Our ref: DOC21/1010019-6
Your ref: SSD 24461956

SSD 24461956 Jerrabomberra High School BDAR Assessment

Attachment 1 – Detailed comments on the BDAR for the Jerrabomberra High School SSD

Figure 9. BAM Vegetation Mapping and Survey

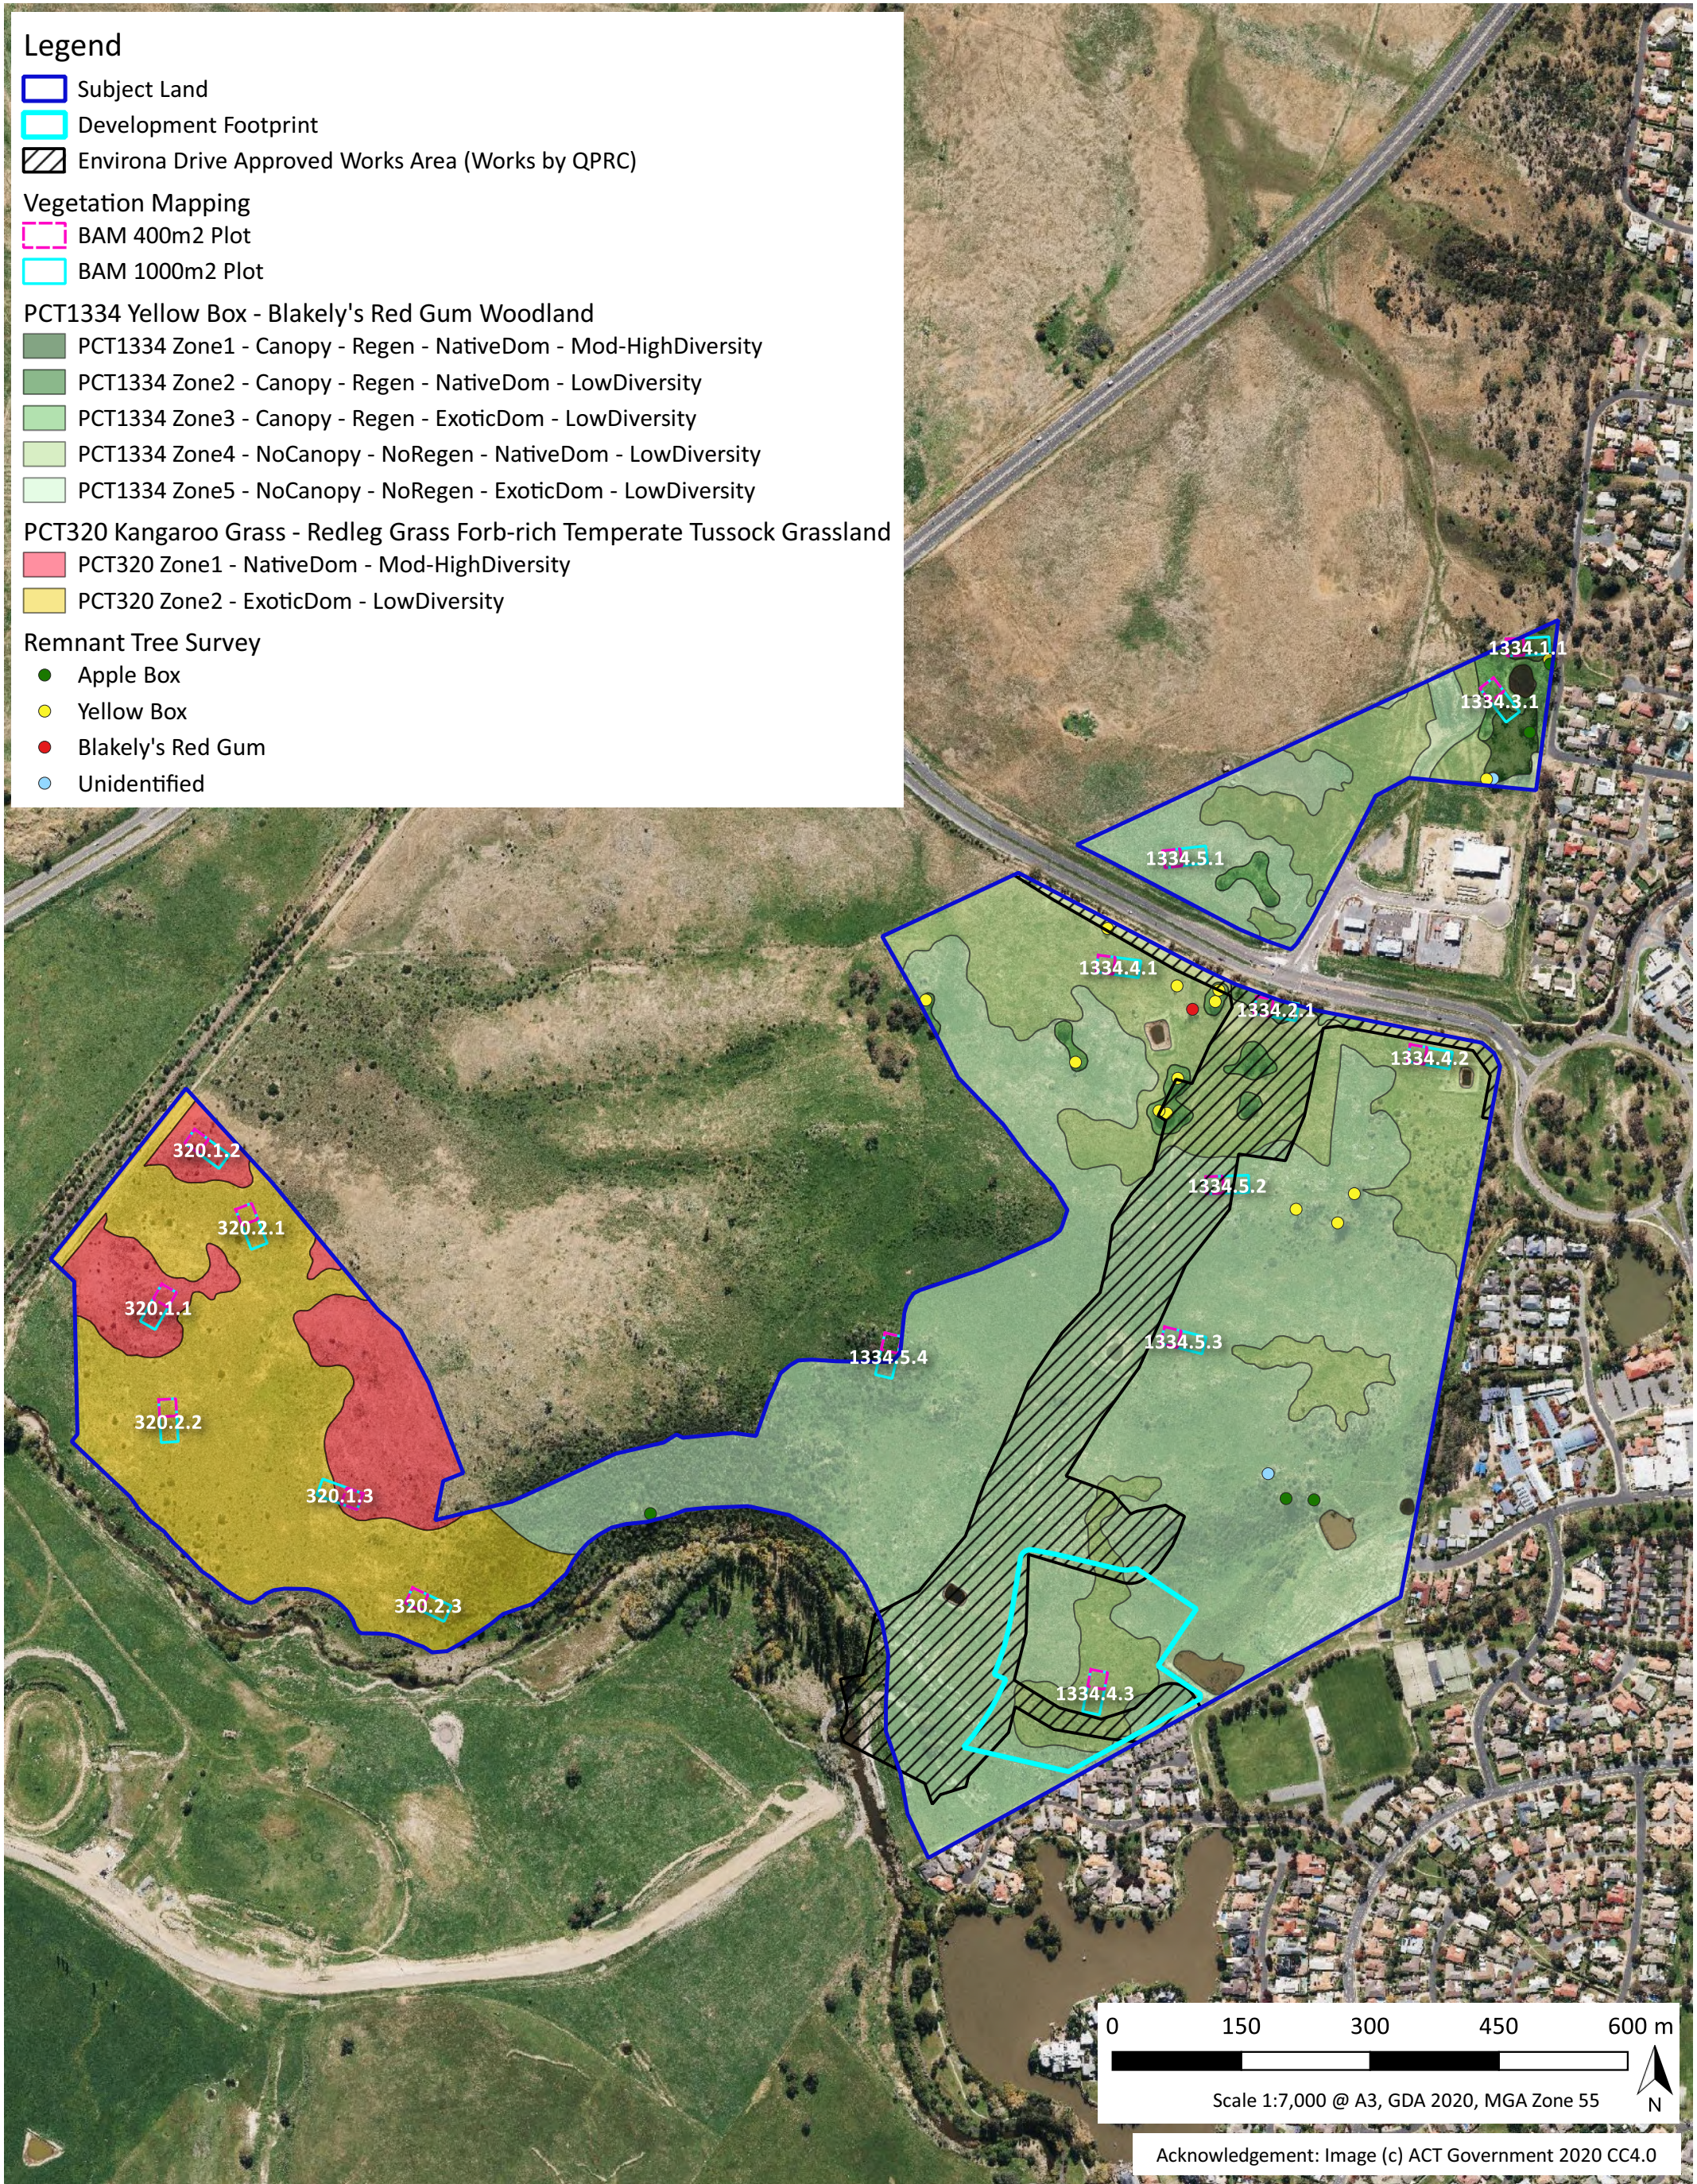
The BDAR states that there is not a BAM plot on the development footprint, however *Figure 9 BAM Vegetation Mapping and Survey* shows a BAM plot numbered 1334.4.3. The BDAR should be updated to reflect this.

- The credit calculation for ecosystem credits – the 'Area Impact' is incorrect and should include the 1.79ha of Zone 5 of PCT1334, in addition to the 1.46ha of Zone 4 of PCT 1334.
- Figures showing native vegetation will need to be updated as Zone 5 PCT 1334 contains native vegetation, regardless of whether it meets the definition of box-gum woodland, or percentage of native vegetation.
